From: Paul Cann <Paul.Cann@arun.gov.uk>
Sent: 11 September 2020 14:34
To: Planning.Responses <Planning.Responses@arun.gov.uk>
Cc: Sarah Burrow <Sarah.Burrow@arun.gov.uk>
Subject: RE: Planning Consultation on: F/21/20/DOC

In note the Civil Engineering Practice (CEP) response to my previous email dated 10th July 2020 with regards to the previous DOC application (F/6/20/DOC). The current DOC application seems to refer to condition no.3 only, however, my comments below also relate to the other outstanding pre commencement drainage conditions ie. nos. 4, 5 and 8, since they are inter related and will help speed up the process.

Application No: F/21/20/DOC
Registered: 26th August 2020
Site Address: Wicks Farm Ford Lane Ford BN18 0DF
Description of Works: Approval of details reserved by condition imposed under ref F/30/18/PL relating to Condition No 3 - surface water drainage.

MANHOLE SW-06
WITH HYDROBRAKE
(Scale 1:25)

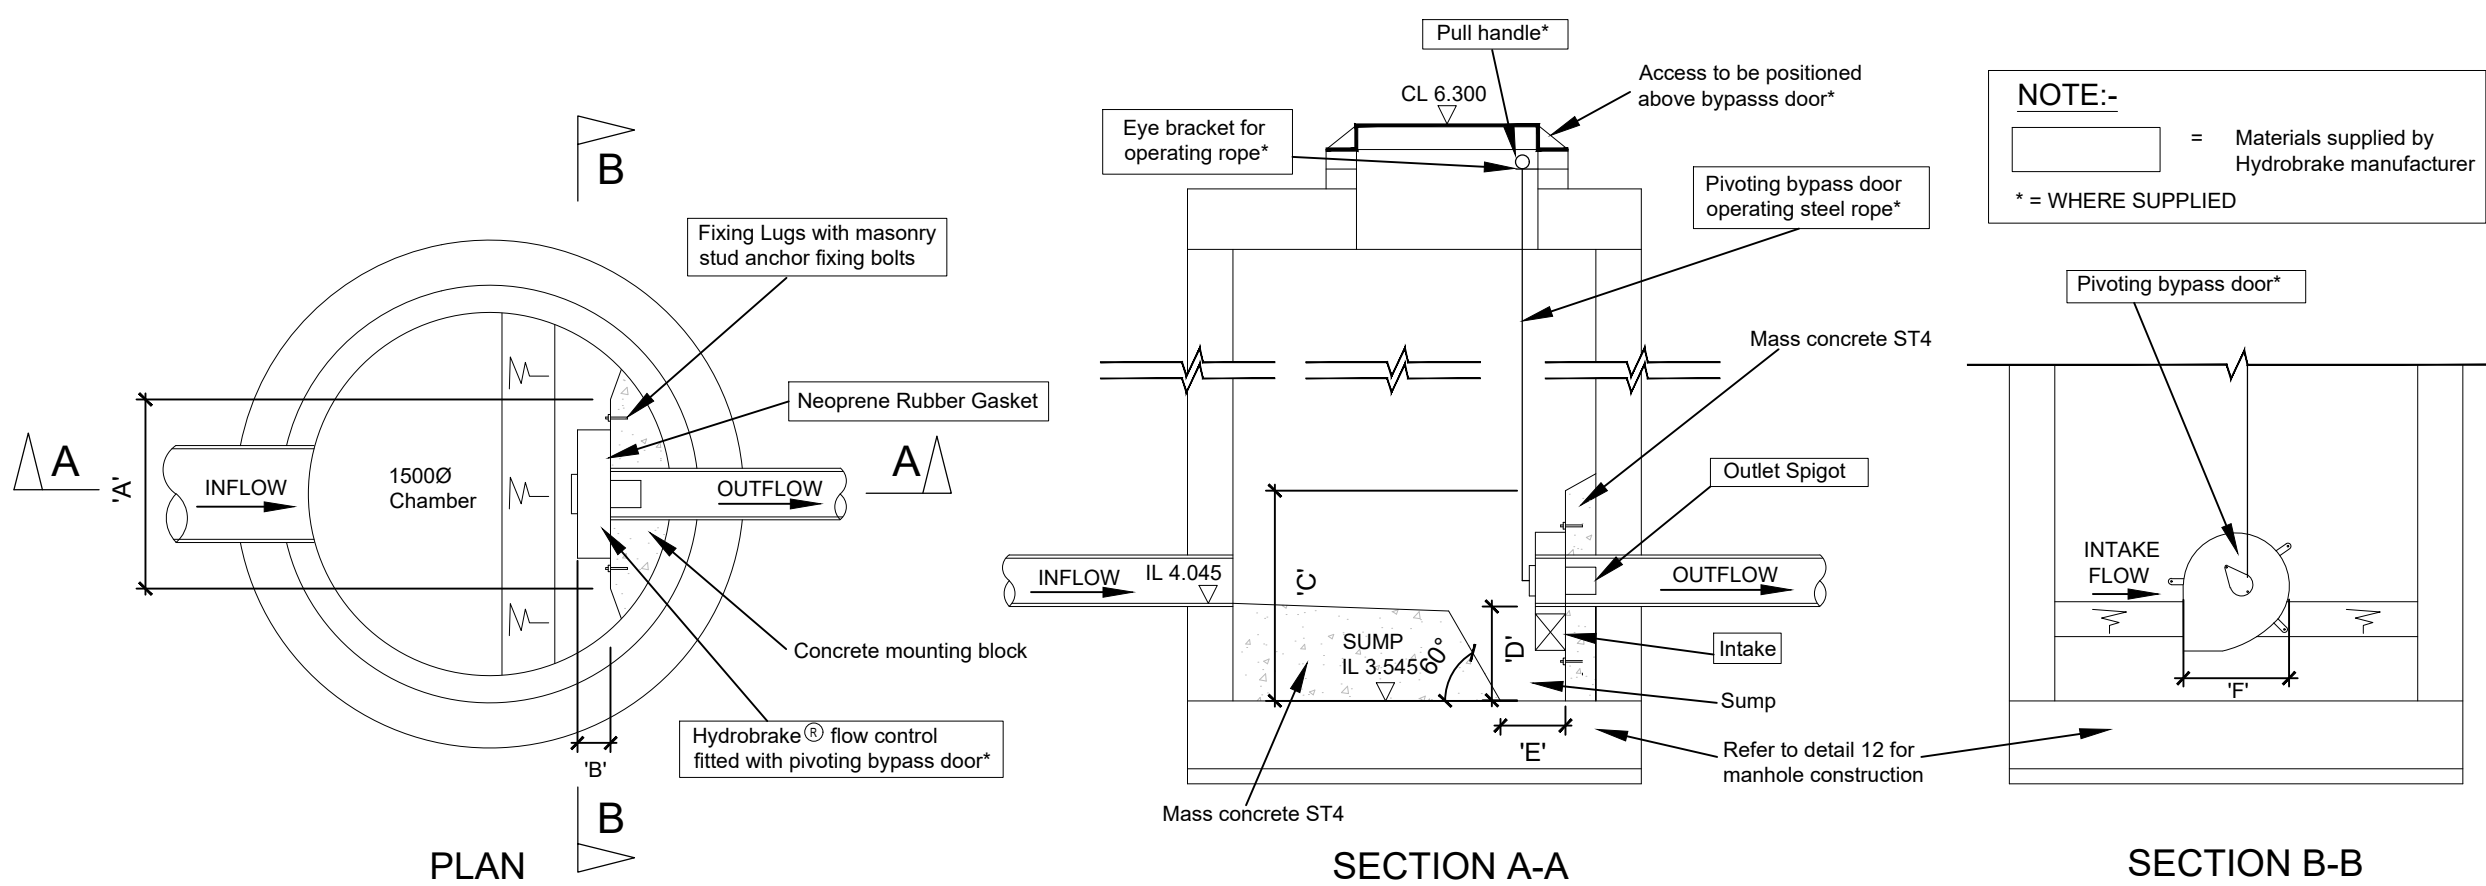
6. **Specify gradient between overflow pipe and hydrobrake chamber.** The gradient is 1 in 44 and is included on drawing 22E. ok
7. **Provide hydrobrake chamber construction detail.** Noted and included in the link above on drawing 52B. Cover level and invert level are to be relevant to SW-07 -- I would suggest just adding a note -- ie. refer to the relevant layout drawing. Whilst the chamber construction details make reference to the details shown on 'manhole construction no.12 drawing', please specifically mention a granolithic finish to the benching

17. **Provide hydrobrake chamber construction detail.** Noted, included in the link above on drawing 52B. See item 7 above -- similar comment applies.
18. **The pond/swale needs a slight gradient east to west (as has been employed on the upstream swales) to improve the hydraulics and ensure water movement. Please note the base level at the eastern end is currently lower than the base level at the western end. Adjust pipe inverts to suit.** The submitted drawings have a 1:400 gradient and pipework has been designed accordingly included in the link above on drawing 24E. ok

ALTHON HEADWALL R10CA
(Scale 1:20)

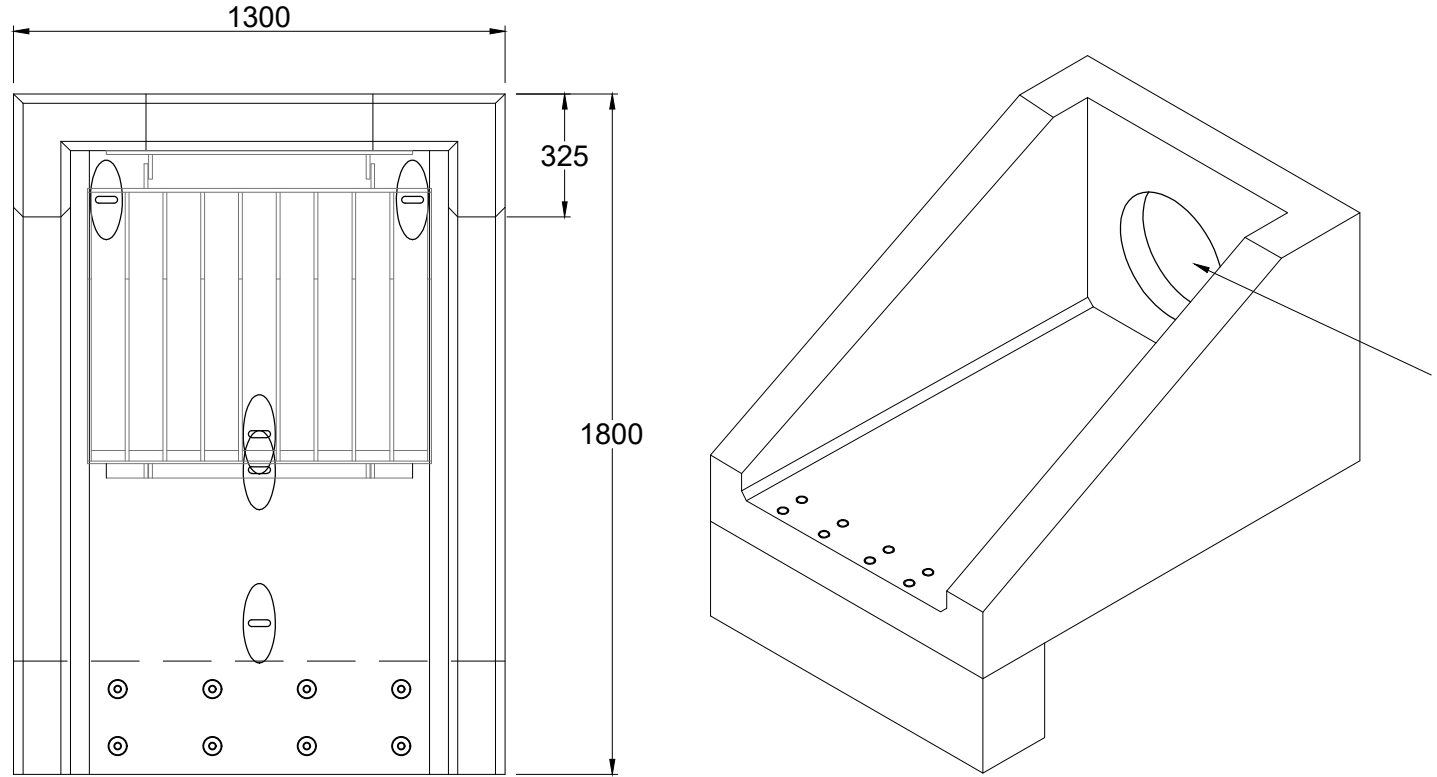
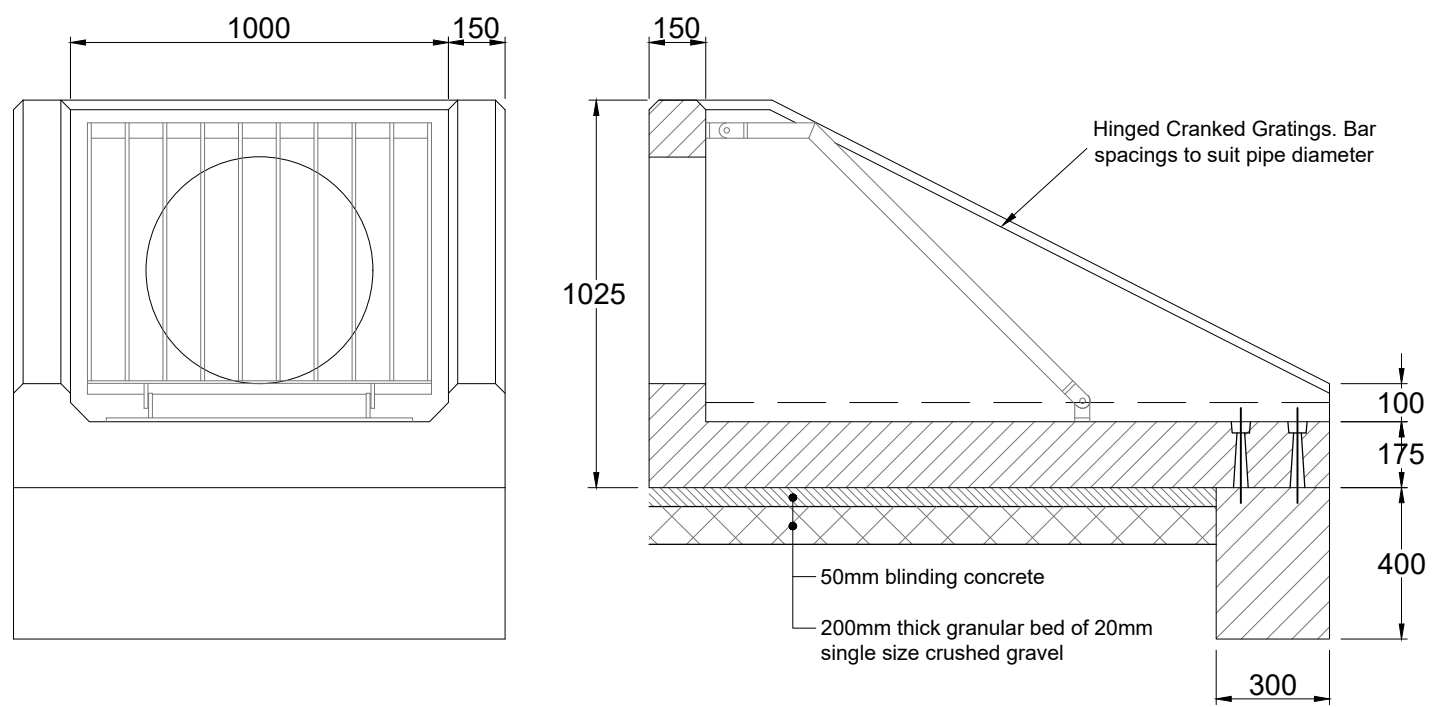
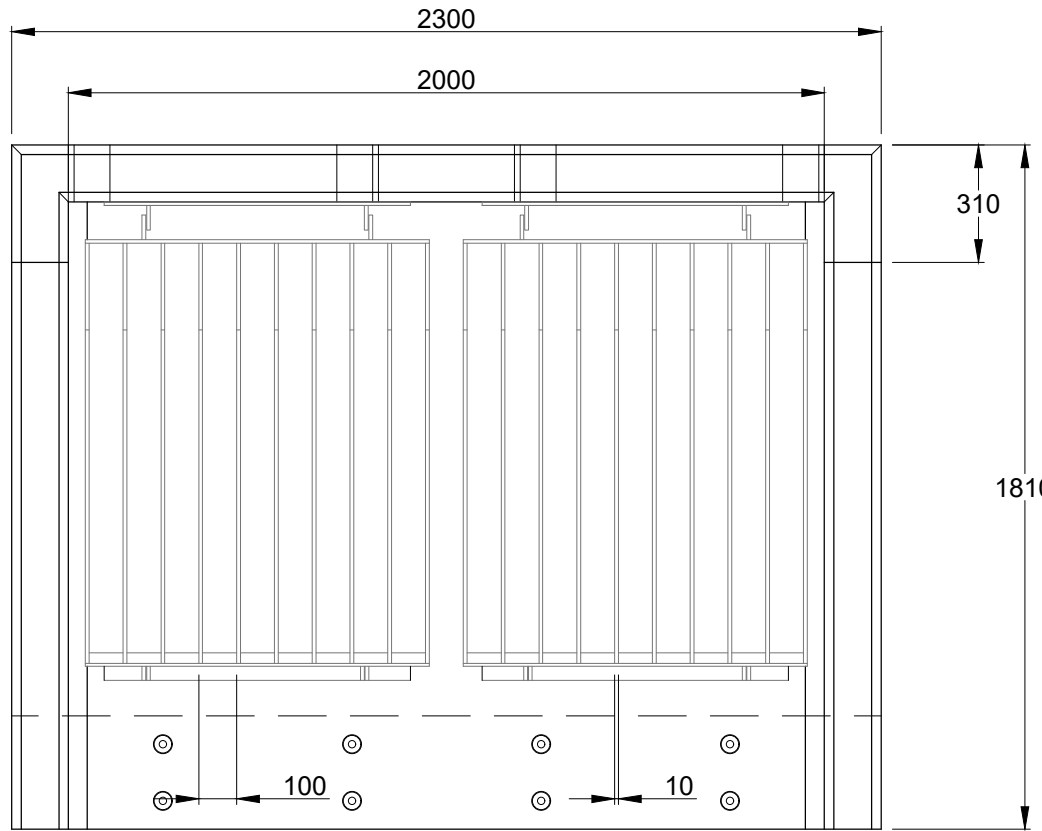
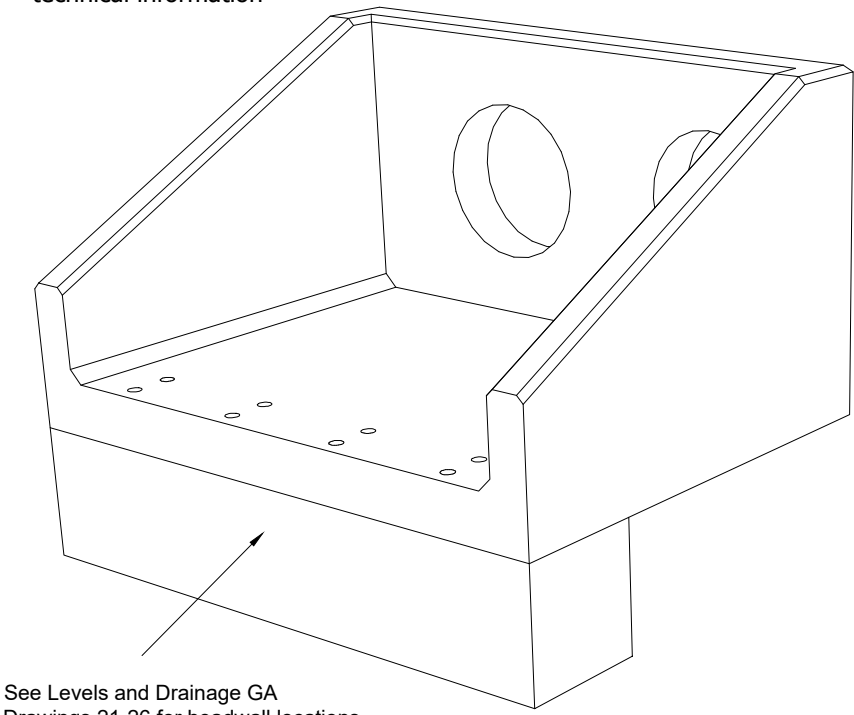
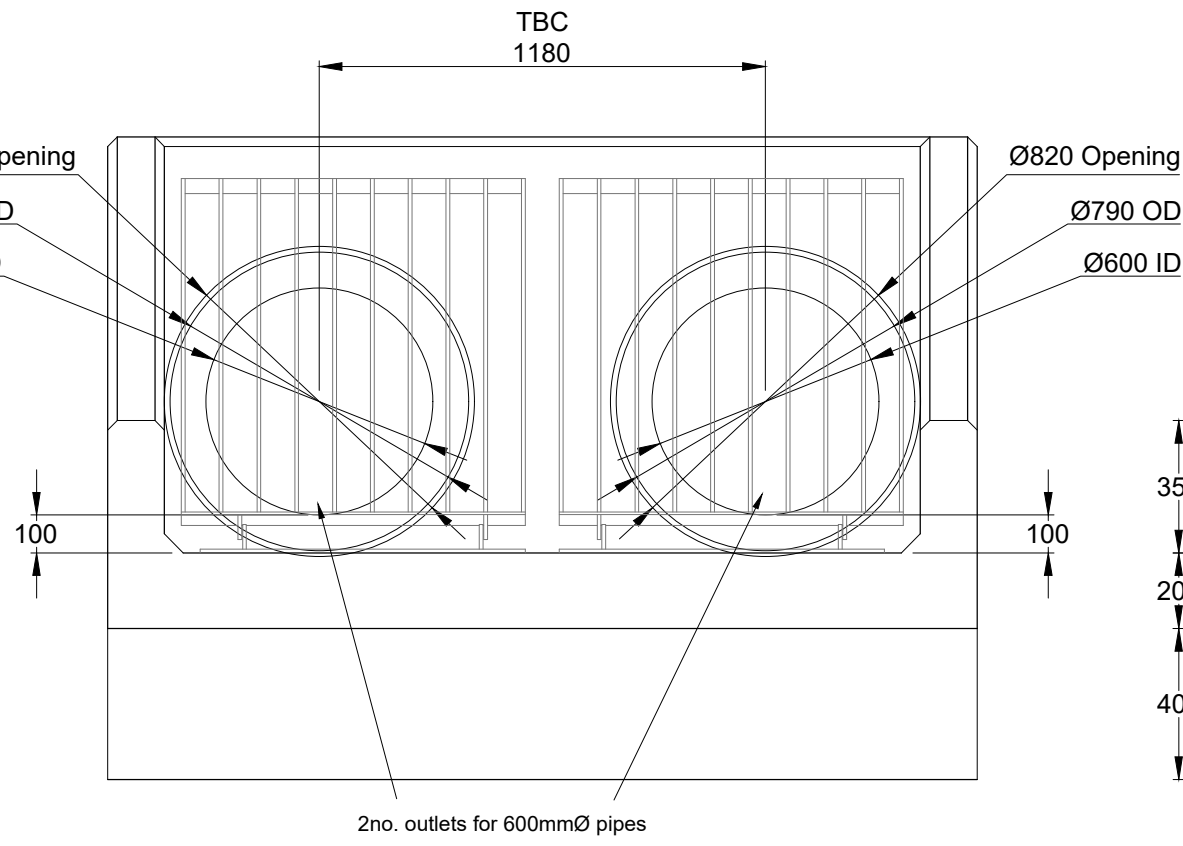
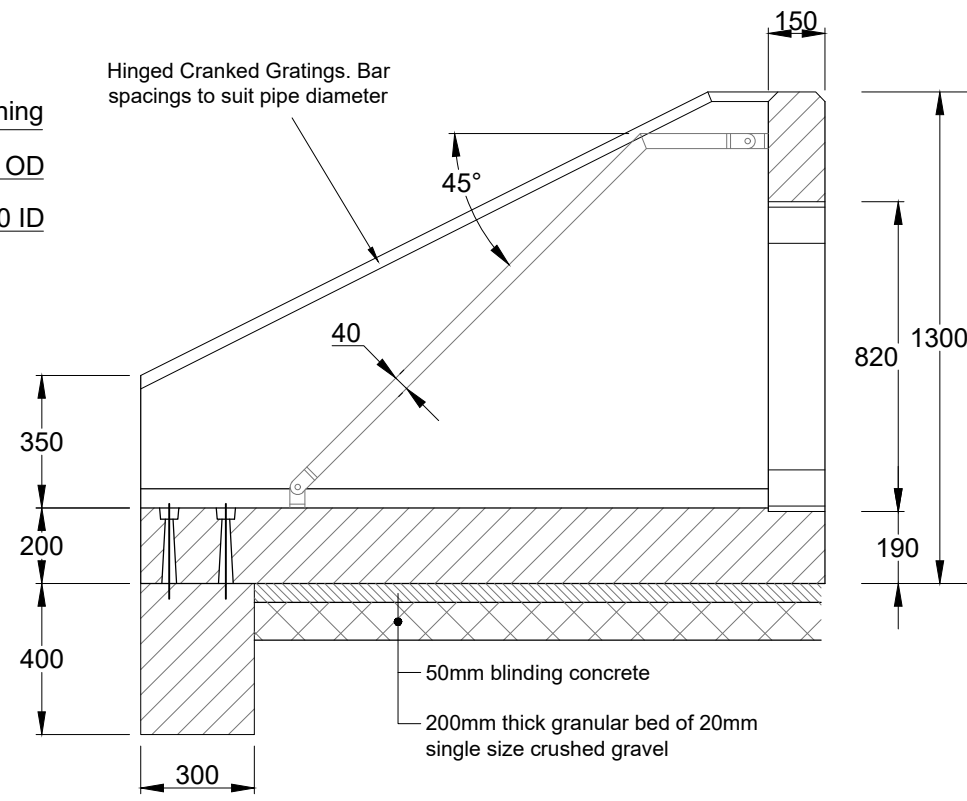
5. **Overflow pipe from reservoir provide headwall with cranked grille with bar spacings to suit 150mm diameter pipe. Include construction detail.** Detail of Althon Headwall R10CA with cranked grill and installation instructions provided on 13 July 2020 and are included in the link above on drawing 53. ok

LONG SECTION - WESTERN DITCH
(Horizontal Scale 1:500 / Vertical Scale 1:125)

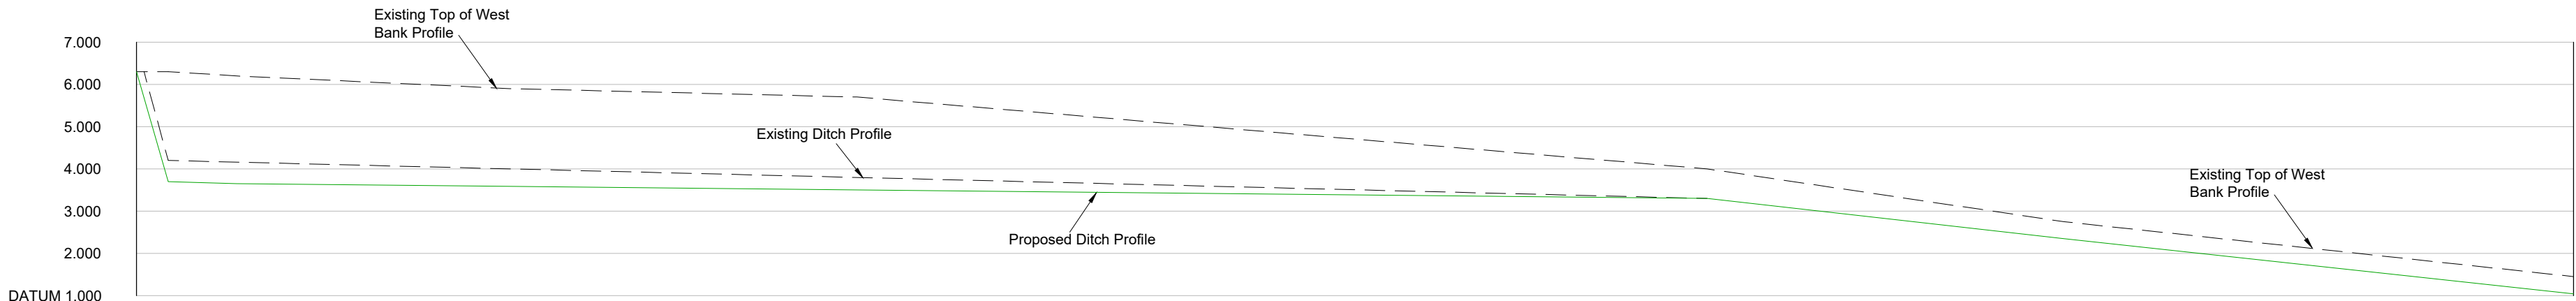
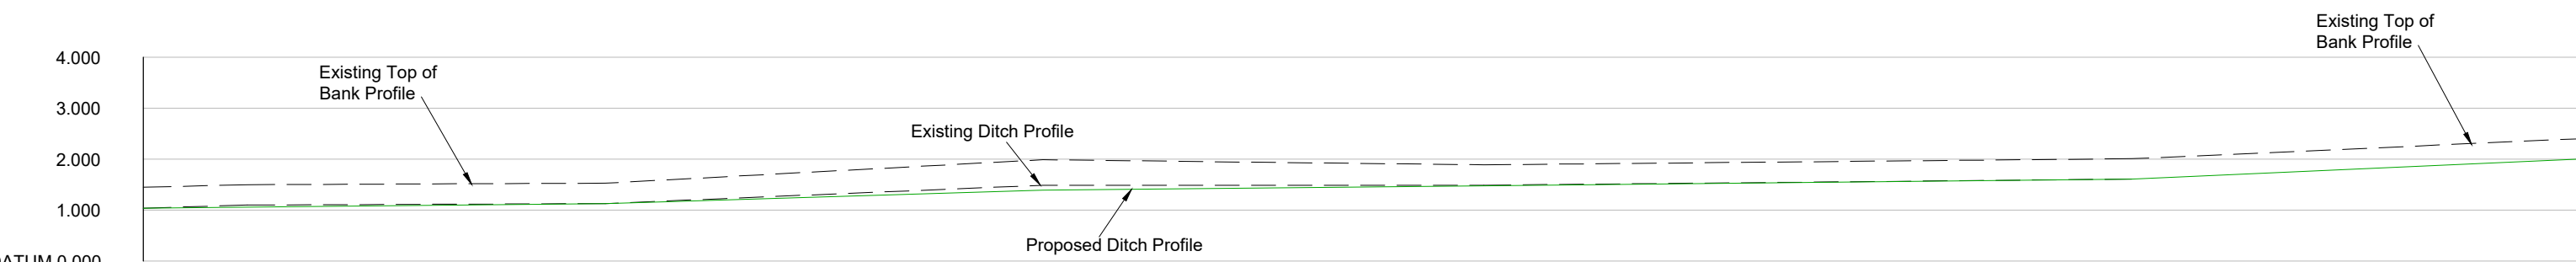
11. **Provide longitudinal section showing existing and proposed bed levels.** This is an existing ditch, we have provided the existing levels on the submitted drawings, long section is included in the above link on drawing 70. ok

13. **If the ditch is being significantly deepened in places then the banks may need reprofiling to avoid them being too steep. Please advise and provide cross sections if necessary. Please also confirm that the regrading/profiling proposals will not have a negative impact on existing trees and their root systems.** The ditch is proposed to be lowered locally at the inflow headwall by up to 500mm the gradient of the

banks remains consistent with other sections of the ditch. Cross sections are included in the link above on drawing 70. ok. Your client needs to give due consideration to any potential impact on existing trees and should seek specialist advice.
